From: Juan Baeza
Sent: 26 February 2019 09:09
To: [REDACTED]
Cc: Kate Giddings
Subject: FW: F/1/19/PL - Unit A1 Ford Lane Business Park Ford Lane Ford BN18 0UZ

From: Kate Giddings
Sent: 25 February 2019 17:17
To: Juan Baeza
Cc: Anna Appleton
Subject: F/1/19/PL - Unit A1 Ford Lane Business Park Ford Lane Ford BN18 0UZ

Floor Plan Scale 1:100@A3

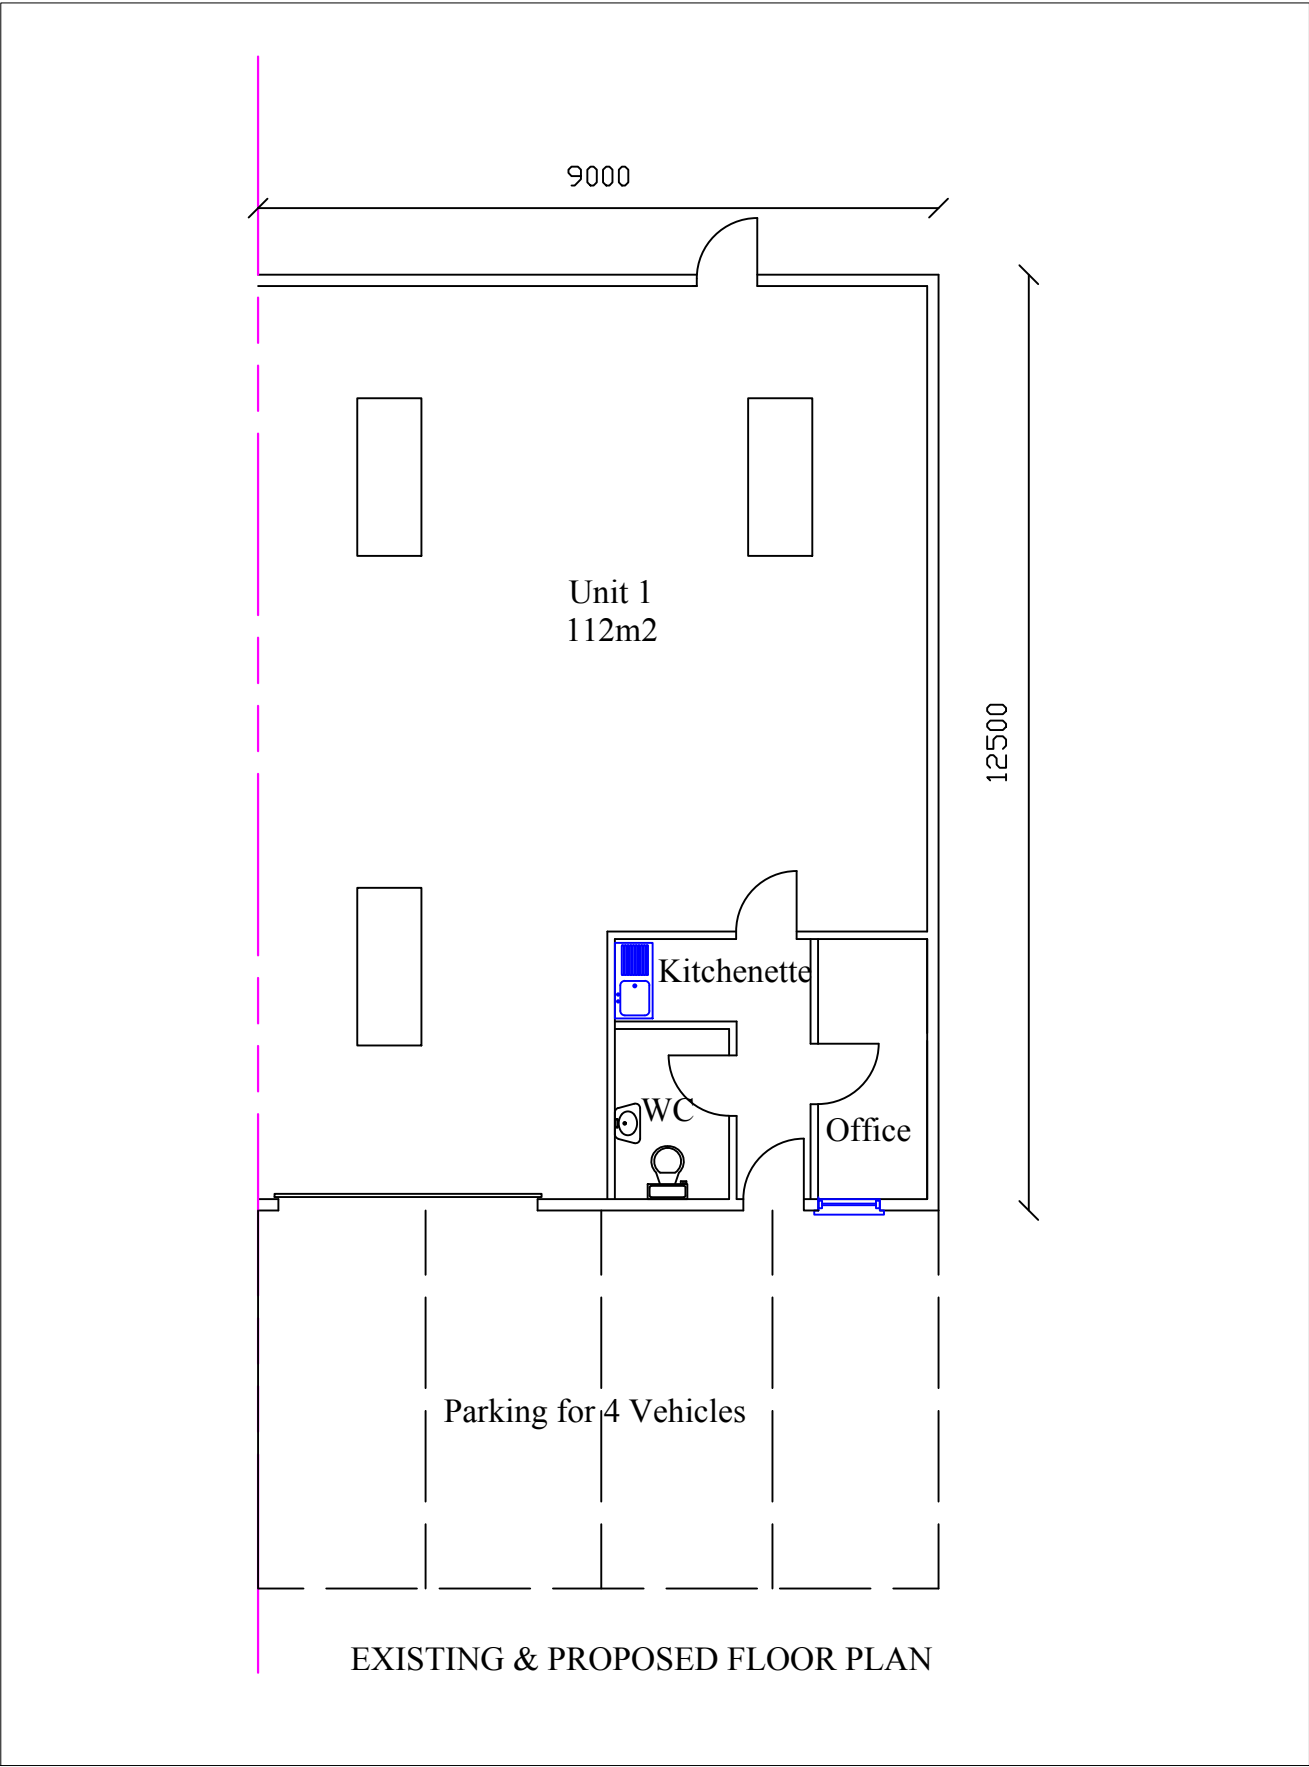
- The plans detail a kitchenette area and WC – for whom is this intended (e.g. staff, customers)?
- The potential for a coffee shop – is this element to be considered with this application or is it an idea for future, separate development?
